From: Simon Davis
Sent: 17 June 2019 12:24
To: [REDACTED]
Subject: RE: FP/57/19/PL - The Malthouse Restaurant, Waterloo Road, Felpham

It will be a delegated decision. The decision is predominantly dependant on the views of the Conservation Officer which I have not yet received. However, please also note that the NPPF states at paragraph 189 that

DRAWING TITLE:
Proposed Floor Plans

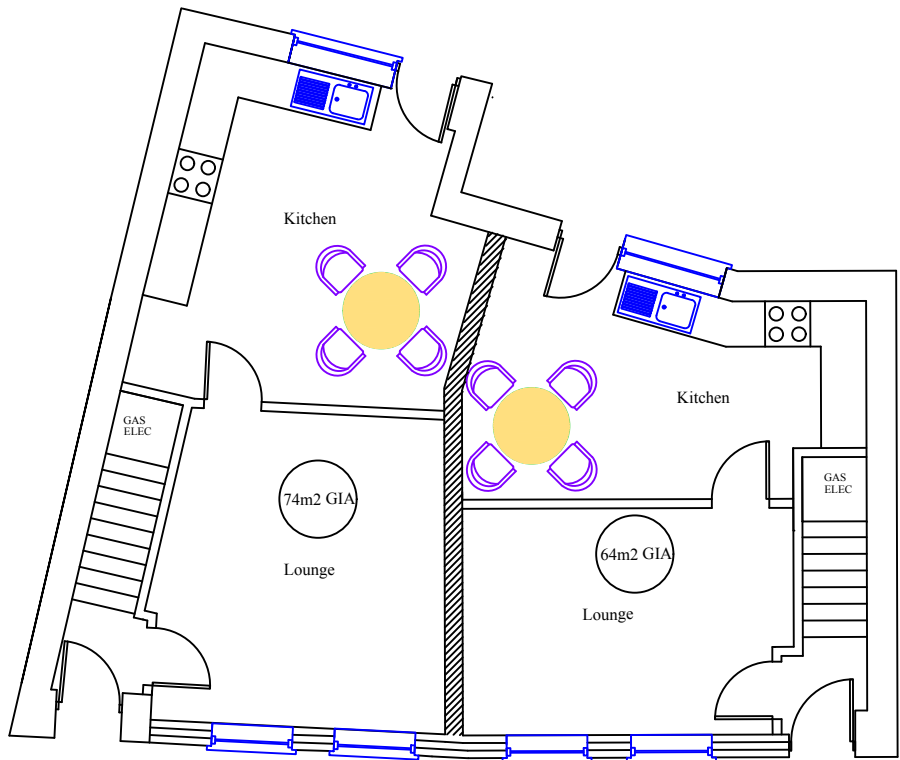
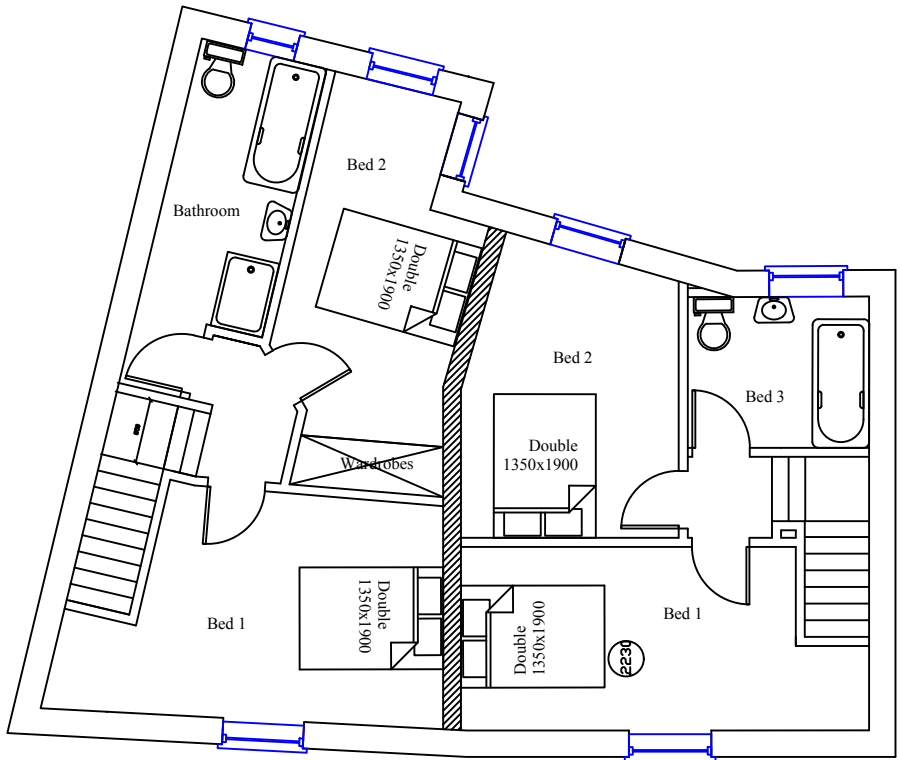
I also have a slight concern regarding space standards in that both flats are shown as having 2 double bedrooms but one of them is only 64m2 in area. The required standard for a 2 bedroom, 4 person dwelling is 70m2. However, can

you confirm the actual size of the bedrooms as it may be the case that if a bedroom is less than 11.5m² in area then for the purposes of the standards it is treated as a single. Two bedroom, 3 person dwellings require only 61m².

I can confirm that the rear bedroom of the 64m2 cottage is 11.0m2 and would therefore request that you consider this cottage to be a 3 person dwelling, all as your email.
